Applicant: Barak & Miriam Olive

Address: 2 Taylor St

Permit # 2014-01440

CHECK-LIST AGAINST ZONING ORDINANCE

ISSUED: 6/25/14
PROJECT No: 1314
DRAWN BY: Author
CHECKED BY: Checker
SHEET TITLE:
ELEVATIONS

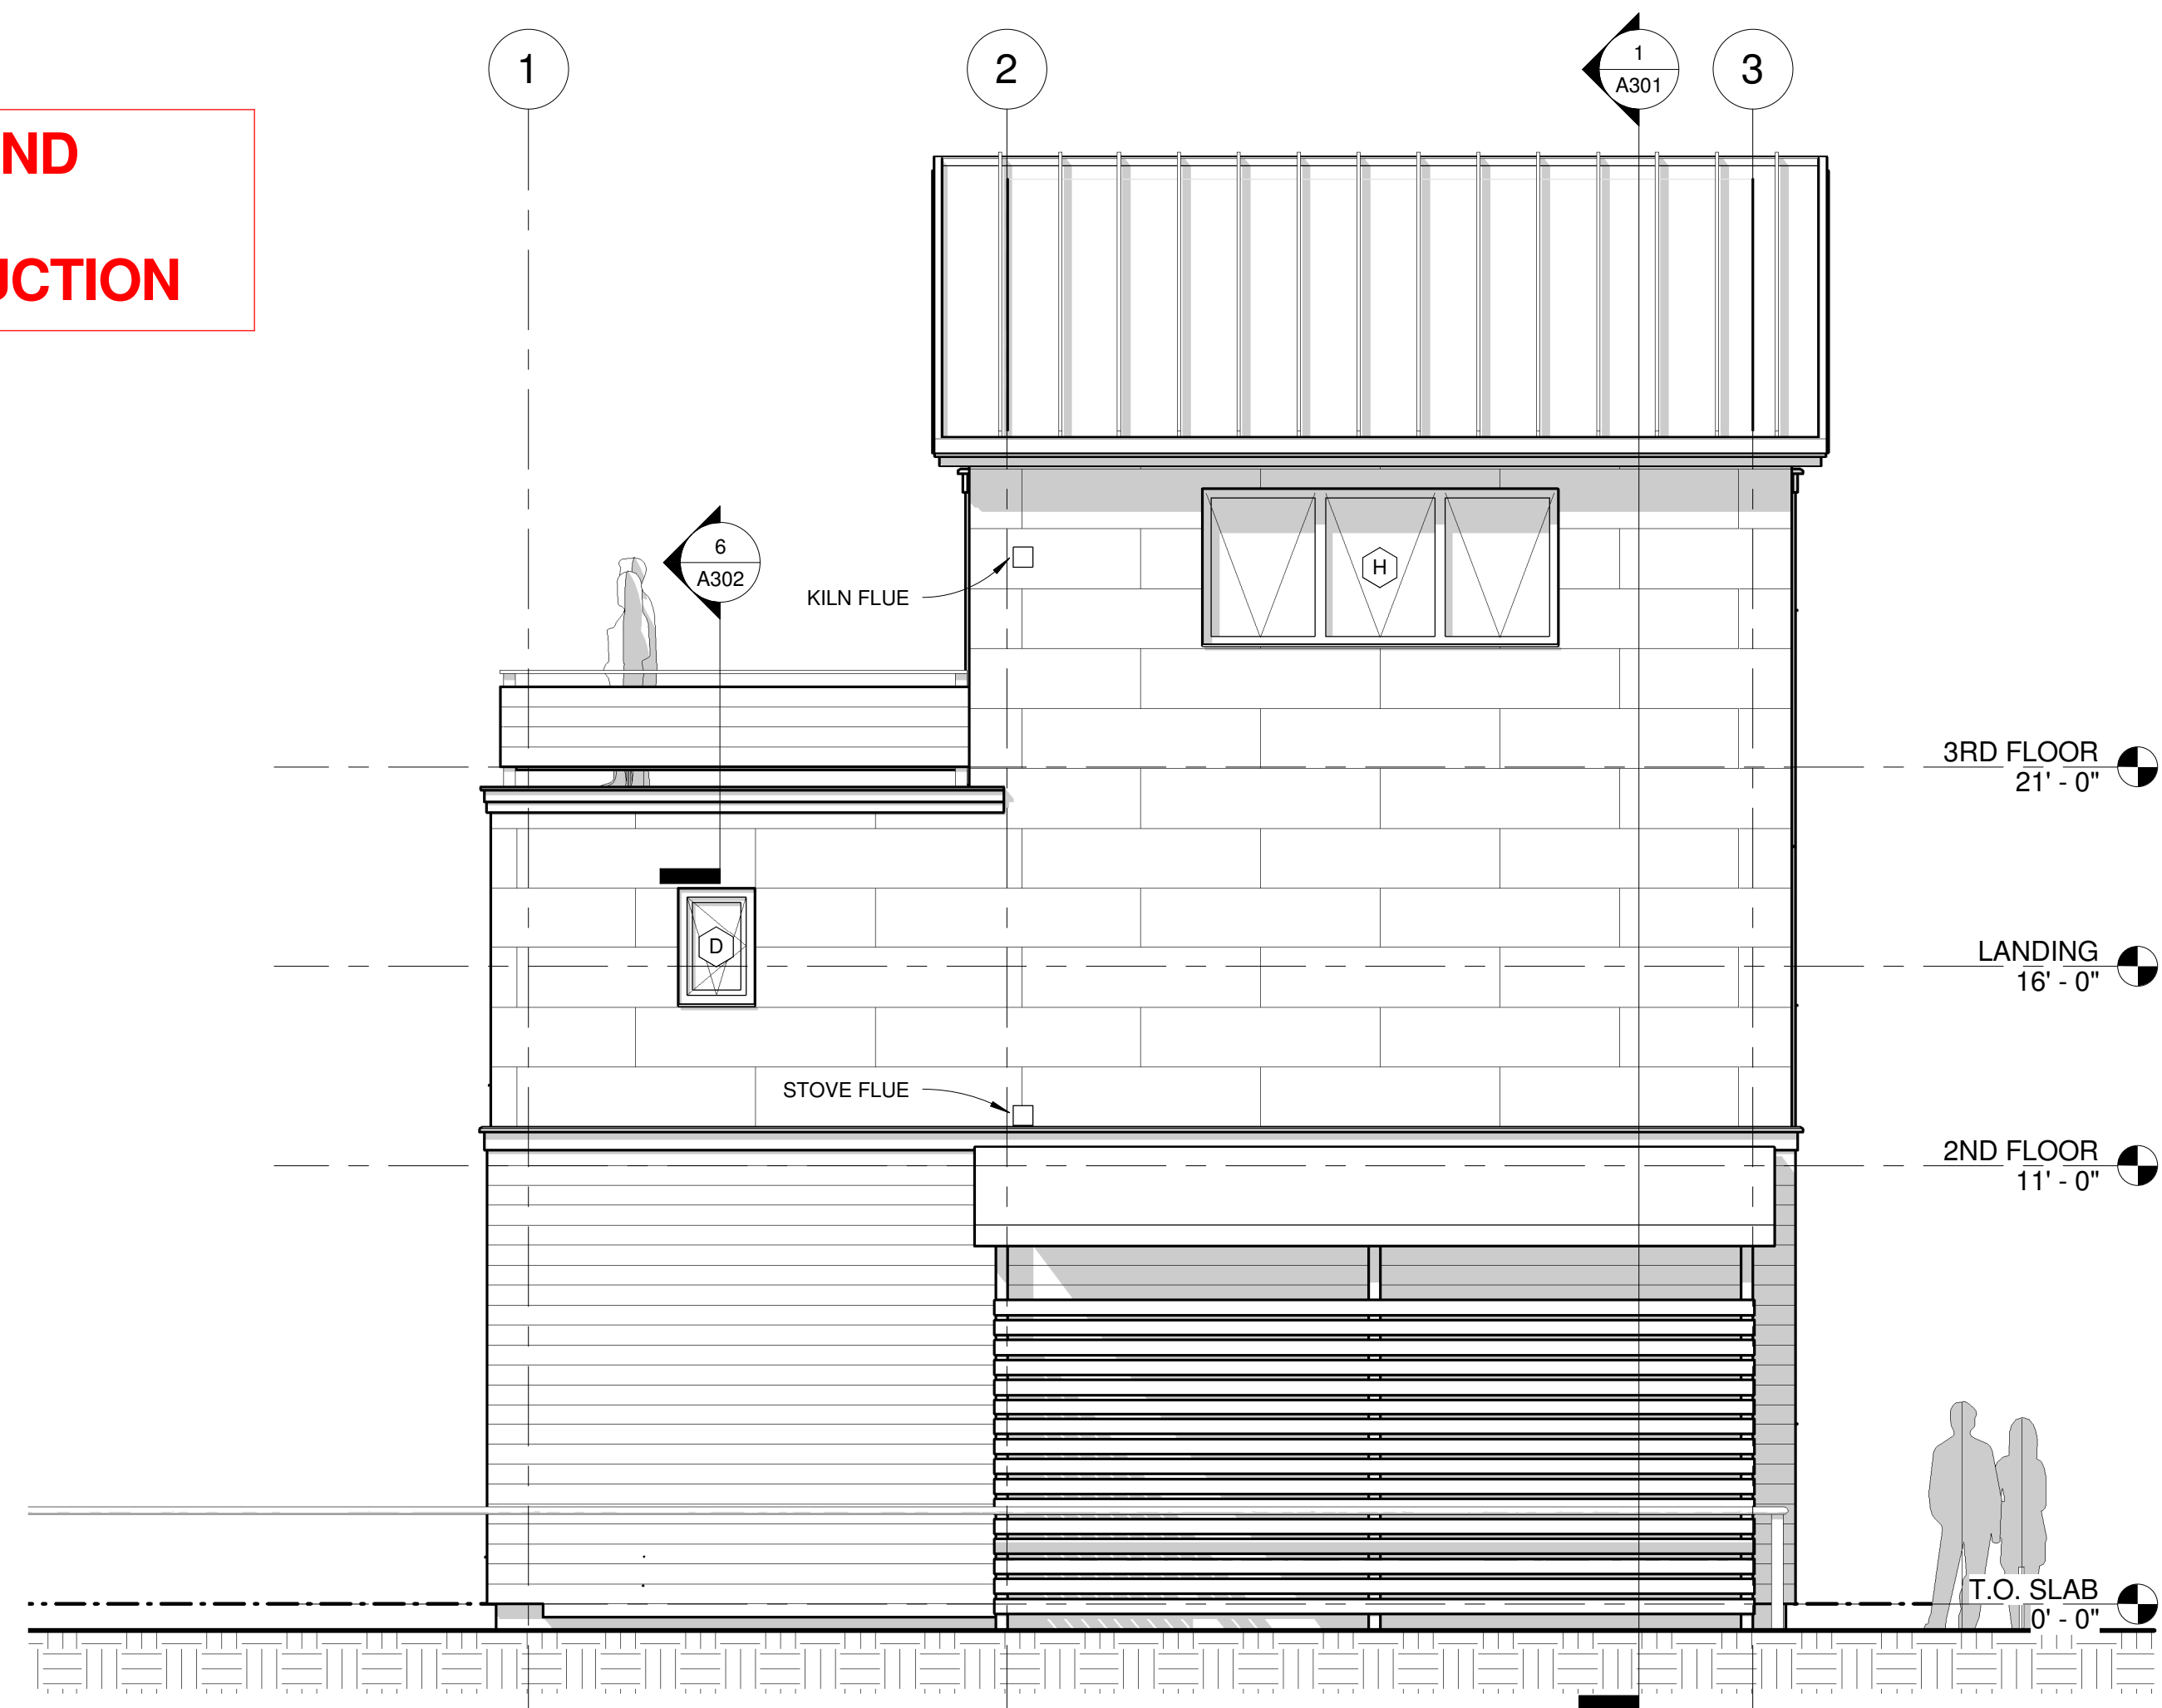
Rear Yard - min of 4' - (10 max height) $\frac{11.5 \text{ scaled OK}}{30.54'}$ + (2 by 12) $\frac{36.5 = 67.04}{34' + 32' = 66'}$ $\frac{12.4'}{13' 8\frac{1}{2}'' \text{ given OK}}$ between buildings (OK)

Height - min - 2 stories above grade of street max 45' - midway scaled is 33.49' ^{Given 36.5'}
